KITTITAS COUNTY

MEMORANDUM

TO: Jeff Watson, Community Development Services
FROM: Kelly Bacon, Engineer Technician I *KB*
DATE: March 17, 2016
SUBJECT: Williams BL-16-00001

The Public Works Department has reviewed the Request for Boundary Line Adjustment Application. In order to ensure that it meets current Kittitas County Road Standards, the applicant needs to provide the following prior to final approval:

CRUSE & ASSOCIATES
PROFESSIONAL LAND SURVEYORS
217 E. Fourth St. P.O. Box 959
Ellensburg, WA 98926 (509) 962-8242
WILLIAMS PROPERTY

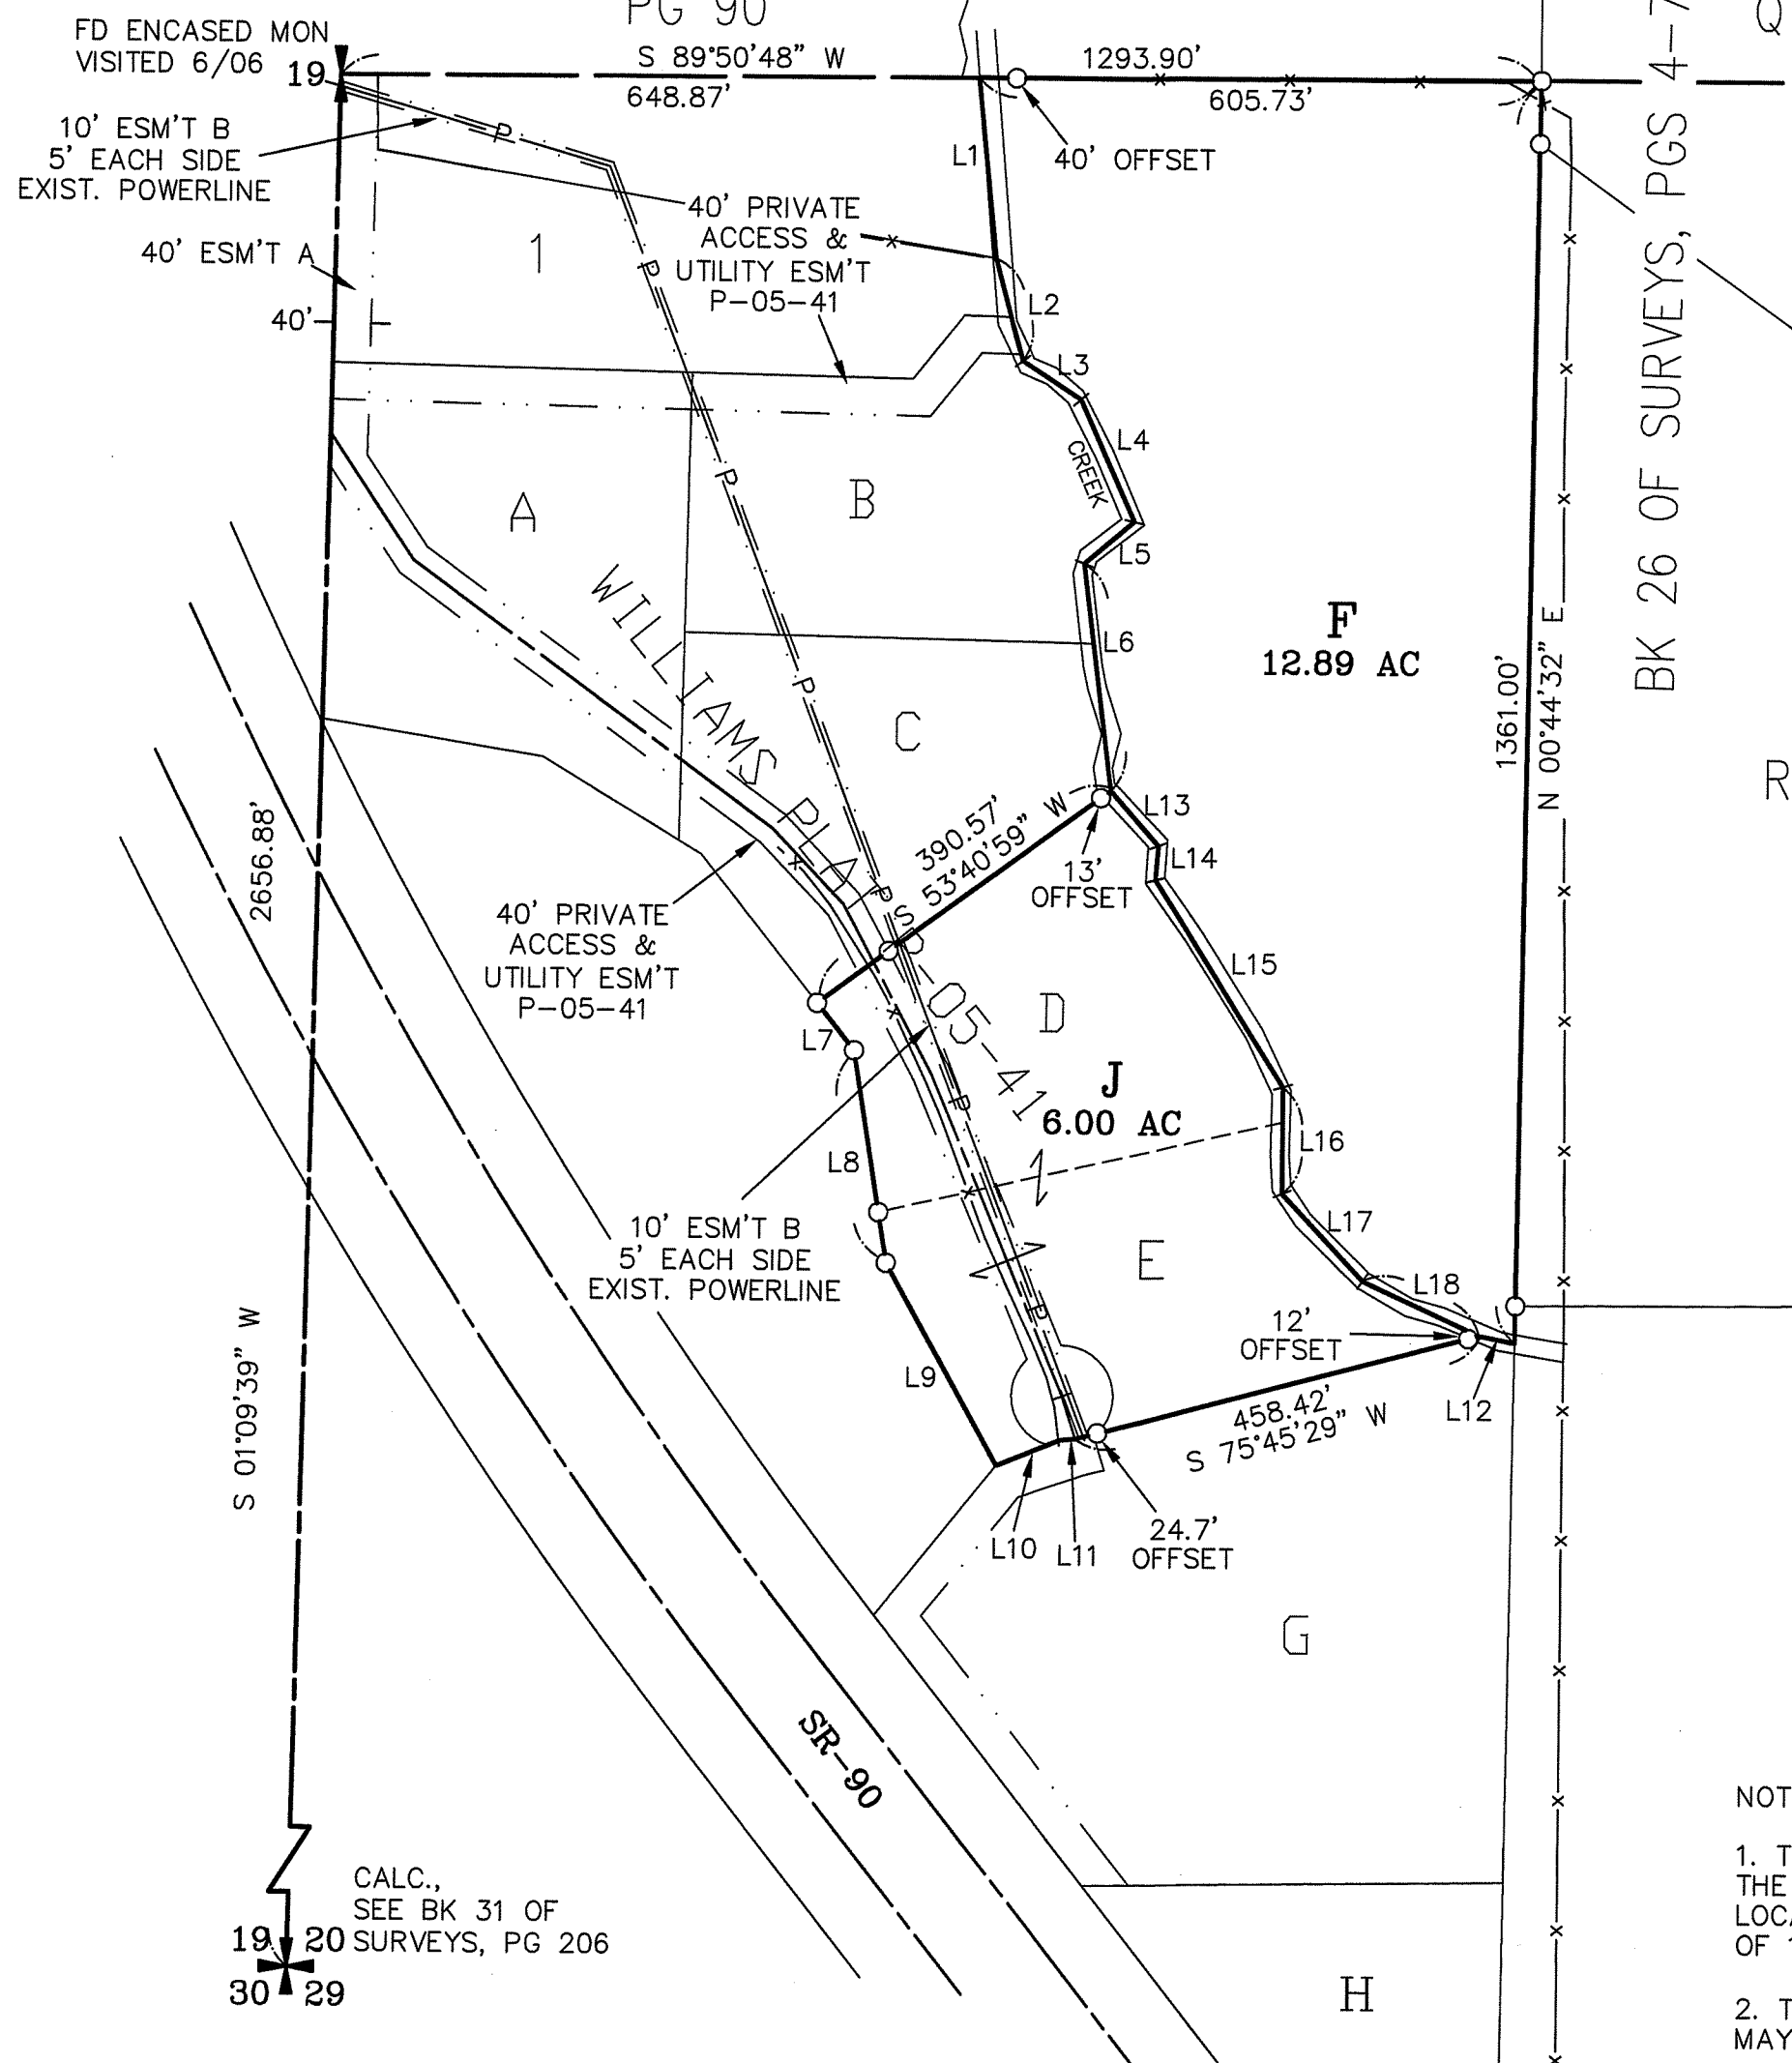
1. Documentation of the easement to access lot F. Easement needs to be shown on the face of the survey.
